Lime Down

Solar Park

Statement of Common Ground with Dorset and Wiltshire Fire and Rescue Service

Document Reference: EXAM/8.13

Title: Figure 3-3: 400kV Substation and BESS Layout

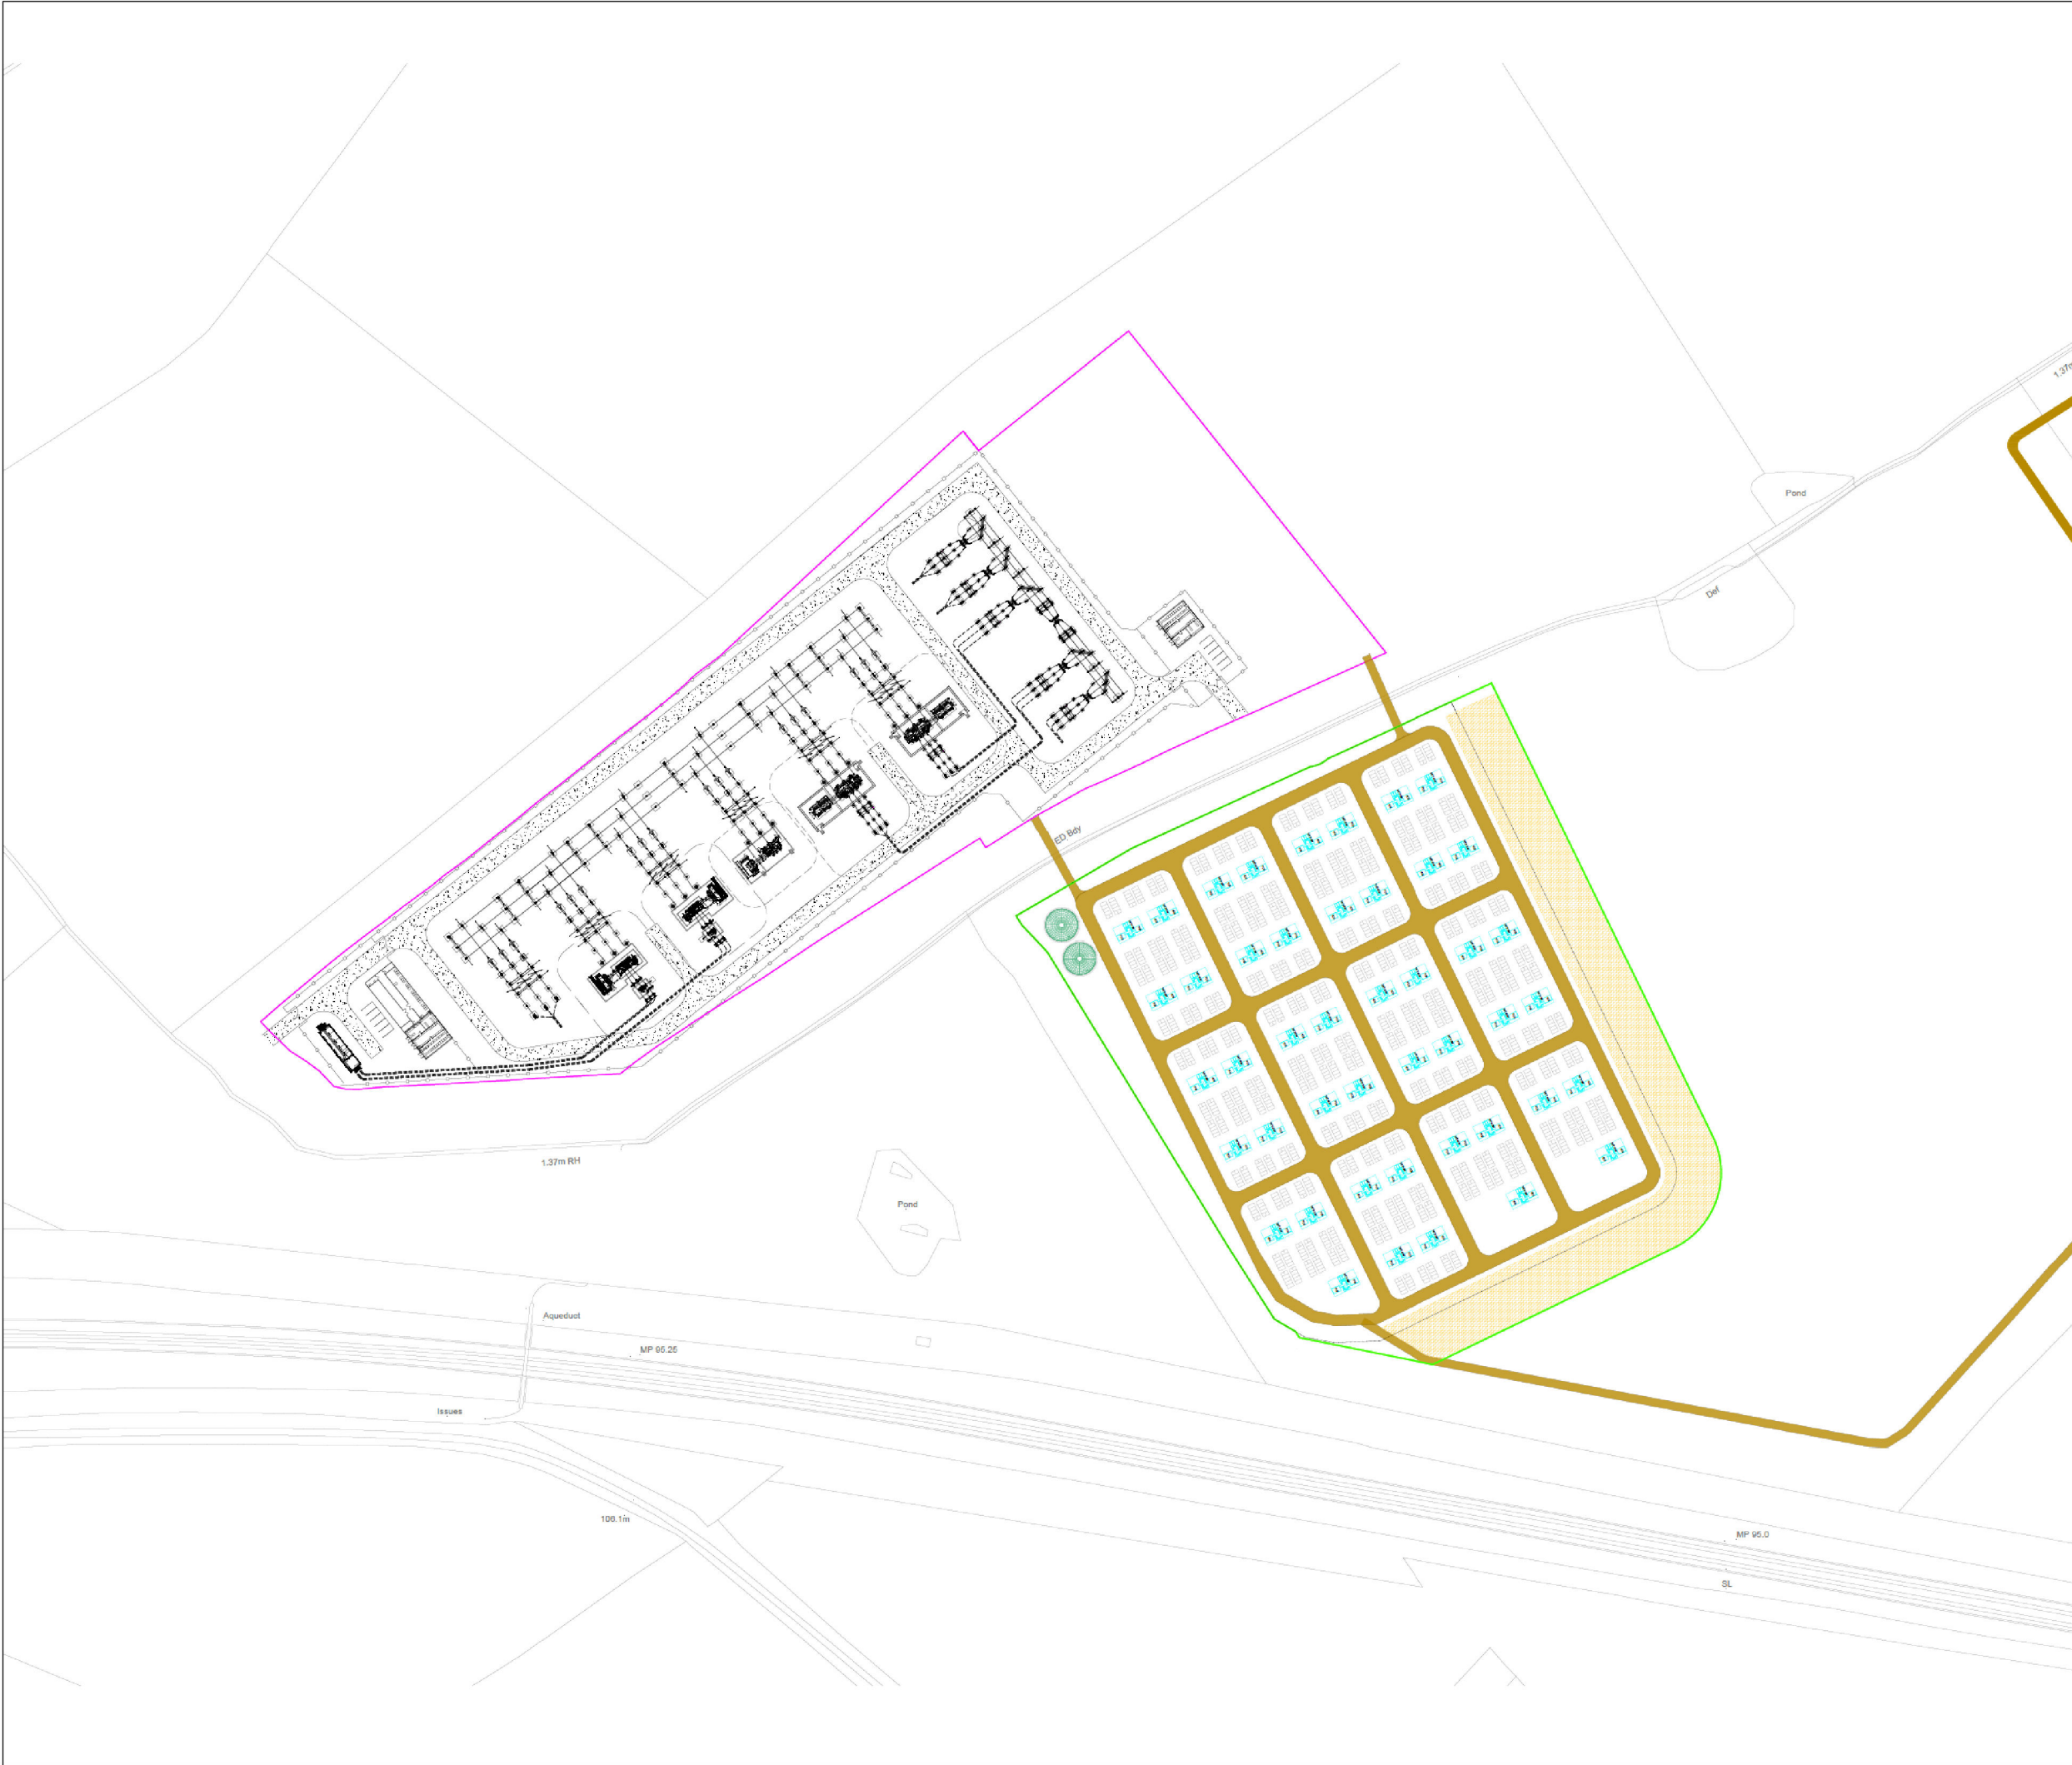
| Reference | Sub-topic | Dorset and Wiltshire Fire and Rescue Service Position | Applicants Position | Status |
|-----------|---|---|---|-------------------------|
| 3.2.5 | Mitigation measures for fire suppression. | <p>DWFRS acknowledges that appropriate consideration has been given to suppression systems and their limitations.</p> <p>DWFRS note that the proposed water supply exceeds current guidance minimum requirements. Reference to automatic suppression or dry pipe access for direct connection with fire appliances is considered beneficial. Hydrant supply from a pumped/ pressure fed system with appropriate outlets within 90m of BESS containers has been confirmed.</p> <p>The applicant has confirmed compliance with UL9540A and NFPA855 in respect of separation between BESS containers, including live fire testing and the use of fire-resistant materials and deflagration</p> | <p>At the detailed design stage, the Applicant will select a BESS design that has undertaken Large Scale Fire Testing (LSFT) which will validate minimum equipment spacing distances, demonstrating that a BESS fire will not propagate to adjacent BESS enclosures and does not require boundary cooling intervention from firefighters.</p> <p>The Applicant will also commission site specific heat flux and flame tilt consequence modelling to account for site topography and wind conditions to establish final equipment spacing distances for the Scheme.</p> <p>Further detail on safe BESS design commitments can be found in the Outline BSMP [REP1-110], Section 4.1.</p> | Under discussion |

| Reference | Sub-topic | Dorset and Wiltshire Fire and Rescue Service Position | Applicants Position | Status |
|-----------|---|--|--|-------------------------|
| 3.2.6 | Design of access roads for firefighting appliances and emergencies. | <p>NFCC Grid Battery Energy Storage Systems Planning – Guidance for FRS Version 1 indicated that two separate access routes should be provided to allow for emergency access in varying wind conditions. Version 2 of the above guidance allows for additional flexibility where perimeter access within the site offers tactical options to manoeuvre within the site.</p> <p>Internal tracks and access roads have been assessed for width, load bearing capability and swept path analysis carried out in compliance with requirements.</p> | <p>The Applicant has worked with D&WFRS to ensure that emergency access routes are appropriate for D&WFRS appliances to operate in all weather conditions. Access roads will be maintained to ensure vegetation does not impede vehicle access.</p> <p>The Applicant confirms road networks within the Order Limits will enable unobstructed access to all areas of the BESS sites. Two separate access routes servicing three separate D&WFRS access points to the BESS site have been integrated to ensure firefighters do not have to drive</p> | Under discussion |

| Reference | Sub-topic | Dorset and Wiltshire Fire and Rescue Service Position | Applicants Position | Status |
|-----------|---|--|--|-------------------------|
| | | | <p>Outline BSMP [REP1-110], Section 5.3.</p> <p>Further detail on BESS site emergency planning commitments (including D&WFRS site familiarisation and training) can be found in the Outline BSMP [REP1-110], Section 5.4.</p> | |

| Reference | Sub-topic | Dorset and Wiltshire Fire and Rescue Service Position | Applicants Position | Status |
|-----------|-----------|---|---|--------|
| | | | <p>through a smoke or gas plume to access the BESS.</p> <p>The proposed access-route width around the BESS area will be 6 m and there are no dead-end access routes or extremes of grade.</p> <p>Further detail on Fire Service Access can be found in the Outline BSMP [REP1-110], Section 5.4.</p> | |
